SUBJECT: PRE-056-17

Residential Care Home and we are proposing to change the use to a HMO.

92-94, Aldwick Road, Bognor Regis, West Sussex, PO21 2PD

RECOMMENDATION:

1 PROPOSED GROUND FLOOR PLAN
1:100

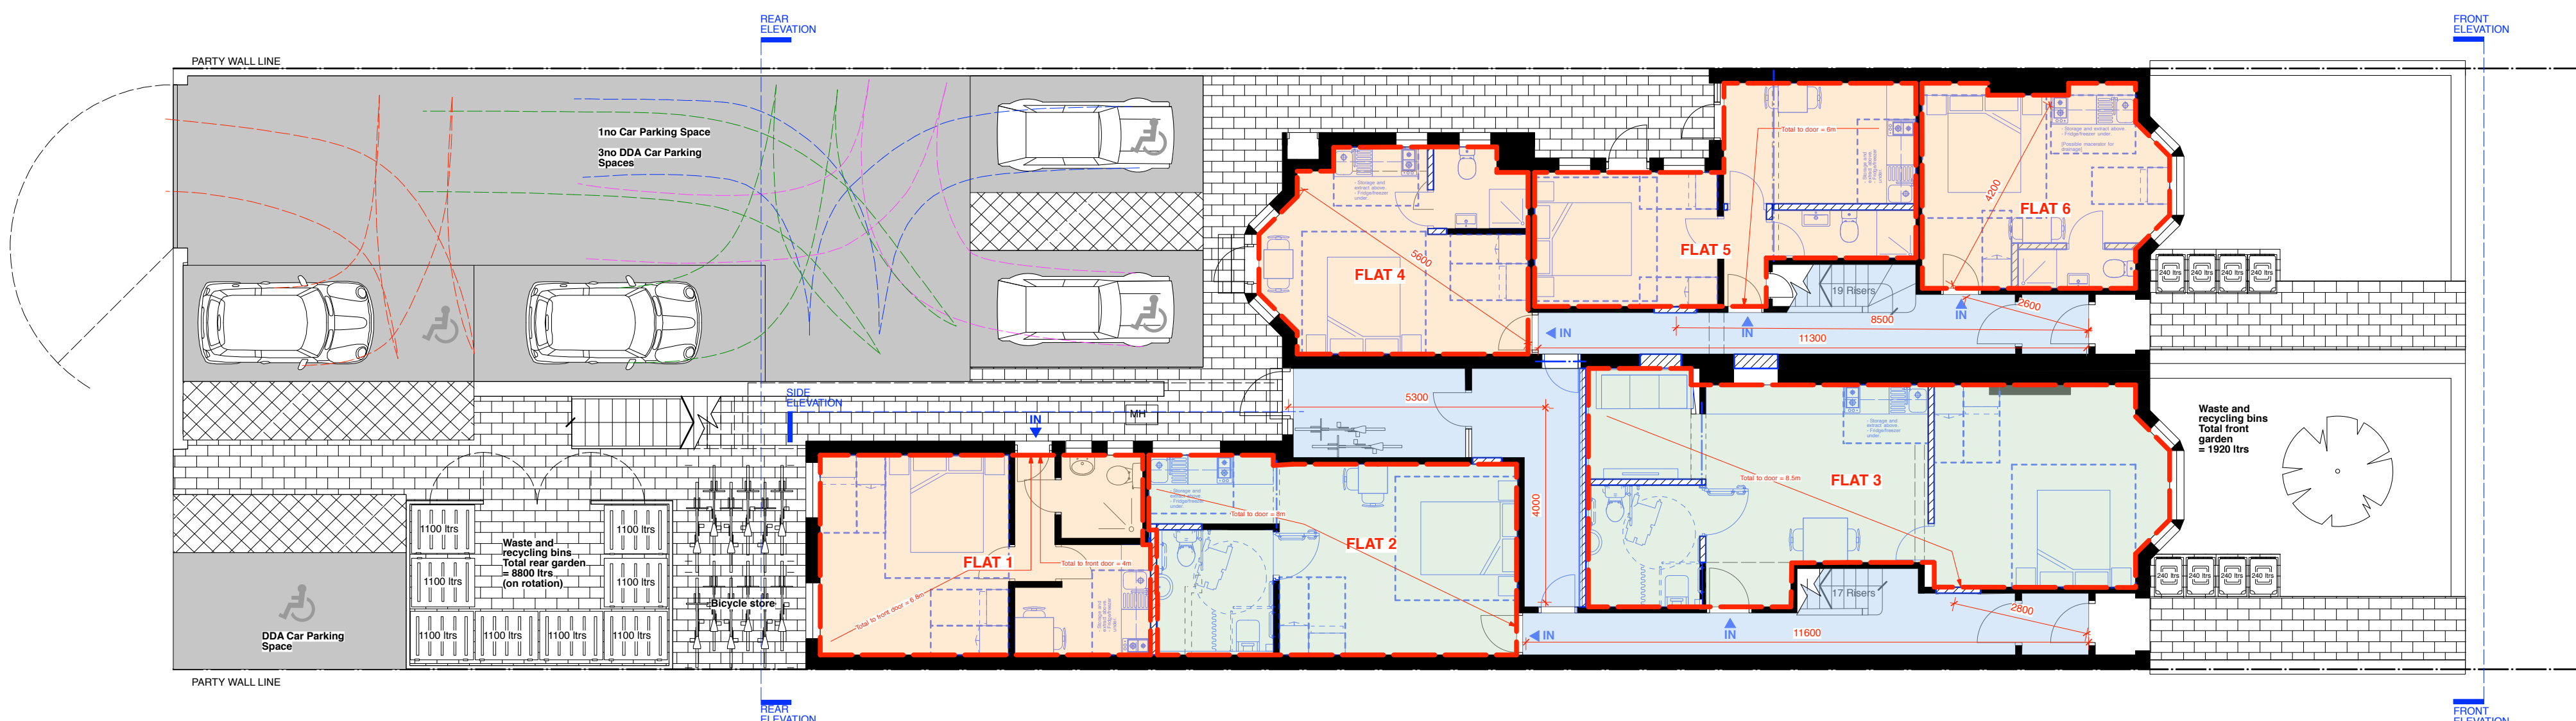
Parking Standards adopted by WSCC in November 2003 provide maximum standards for car parking provision. An HMO use could see a demand for 0.5 spaces per HMO unit/room. The floor plans appear to show 22 rooms therefore the HMO could result in a maximum demand for 11 car parking spaces. This is anticipated to be an increase over the demand the existing C2 use care home could have created. The existing plans appear to show 20 rooms. Parking standards for this use require 1 car parking space per 20 residents plus visitor parking of 1 space per 8 residents and staff spaces of 1 per five residents. A maximum demand for 8 spaces results. Nevertheless it is likely that the rear parking area via the private road was not in use for visitor parking with the care home use and only provided staff space.

Four car parking spaces to the rear will be provided plus an additional disabled car parking space. Whilst there is a shortfall vehicle movements are likely to be concentrated to peak times with the HMO use and the standards are a maximum where a "zero standard is not considered appropriate" some provision will be in place. Parking restrictions on street nearby would ensure that any overspill parking could not occur in locations that would be detrimental to highway safety and would be an amenity issue for the LPA to assess.

The workability of a car separately being able to access each space may be required to be demonstrated at full application stage. We appreciate that access is via a private road and thus the ability to turn on site, whilst preferential, would not be reason to resist the proposal.

I would advise increasing the bicycle storage where possible. There is no separate standard for bicycle storage with an HMO use thus considering the location proximity to rail station would advise that bicycle standards applied to a 1 bed flat be used (0.5 space) therefore 11 cycle storage spaces are advised.
